Re: Rand-Milestone Short Plat  
7621 SE 22<sup>nd</sup> Street  
Mercer Island, Washington  
CAO 21-004

This letter provides geotechnical review comments for the above-referenced project. The proposed short plat was reviewed for compliance with Mercer Island City Codes (MICC):

JOB NO. 17090
DATE 6/17
SCALE 1"=10'
DESIGNED CLM
DRAWN CLM
CHECKED RSB
APPROVED RF

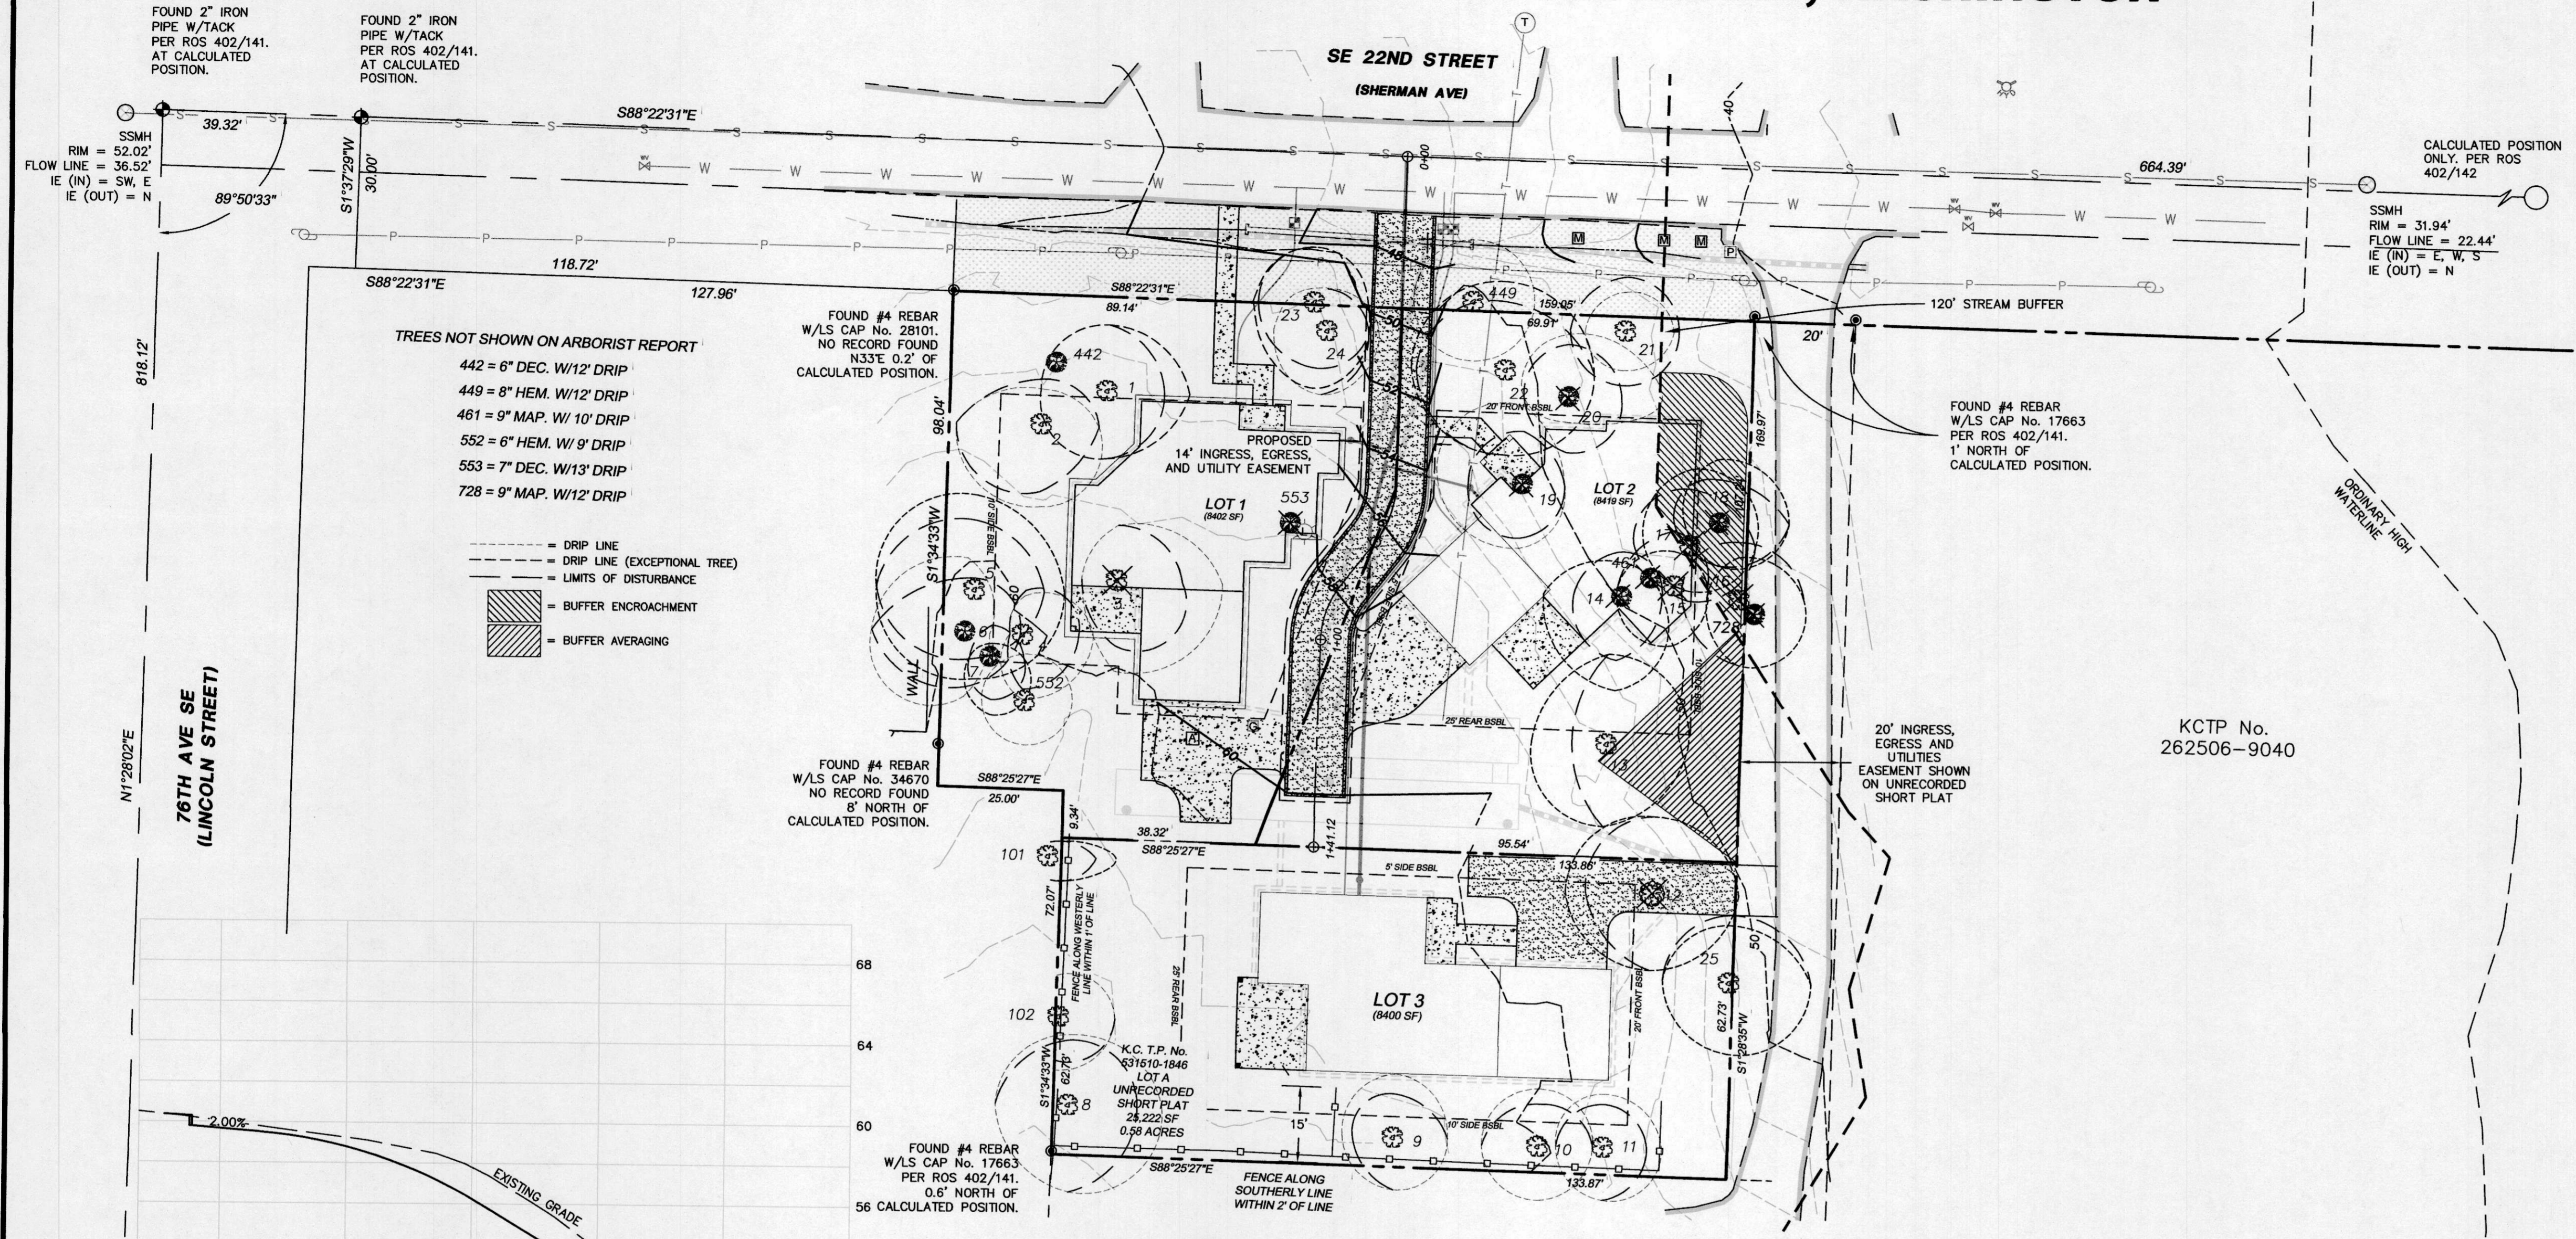
It appears that Lot 2 is located over the sloped portion (also designated landslide hazard) of the site. No final grading is provided in this area.

**Comment 4:** This code section (MICC 19.09.090) cannot be met without meeting code section MICC19.07.160. Provide proposed final grades for the proposed lots. Provide information regarding proposed building excavation, e.g., will basement levels be involved? Provide an anticipated basement level elevation or finished floor elevations for at-grade structures for the proposed lots.

Adequate grading information should be provided for Lot 2 so that the geotechnical engineer can assess potential slope stability impacts and provide design mitigation recommendations.
